CHANGES TO DRAFT APPLICATION FILE

VOLUME 3D - MSA

VOLUME 3D EIS - MSA - MAIN TEXT				
Chapter	Section	Para.	Figure / Table	Summary of Changes
4	TOC			Chapter 3 updated to Chapter 4
	TOC		Figure 6.3.2	Deletion of capital letter
	TOC		Figure 11.2	The word "sheet" added
	TOC			Photomontage 43 hyphen deleted
	TOC			Photomontage 44 hyphen deleted
	TOC			Photomontage 45A hyphen deleted

Figure 13.1: Indicative Corridors of the Proposed Leinster Orbital Route

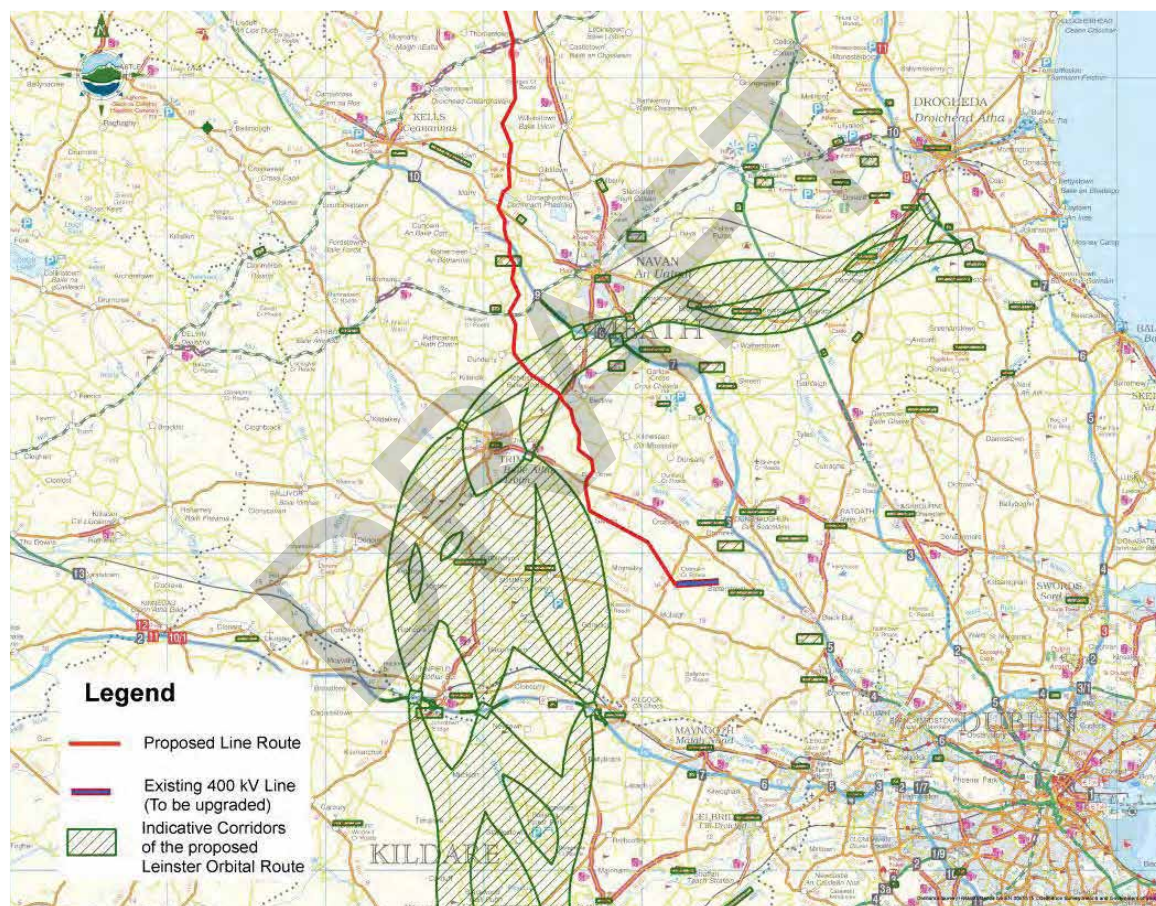
Chapter	Section	Para.	Figure / Table	Summary of Changes
13	13.4.4	51		New text added to paragraph referencing a new Figure 13.1 which shows the indicative corridors of the proposed Leinster orbital route and their relationship with the proposed development.
13	13.4.4		Figure 13.1	New Figure 13.1 added <i>Indicative Corridors of the Proposed Leinster Orbital Route.</i> <i>Should this be Leinster??</i>
13	13.5.2.1	57	Table 13.5	Update of movements for transposition tower row 2, column 2
13	13.5.2.1	57	Table 13.5	Update of movements for transposition tower row 2, column 3
13	13.5.2.1	57	Table 13.5	Update of movements for transposition tower row 2, column 4
13	13.5.2.1	57	Table 13.5	Update of movements for transposition tower row 2, column 5
13	13.5.2.1	57	Table 13.5	Update of movements for transposition tower row 2, column 6
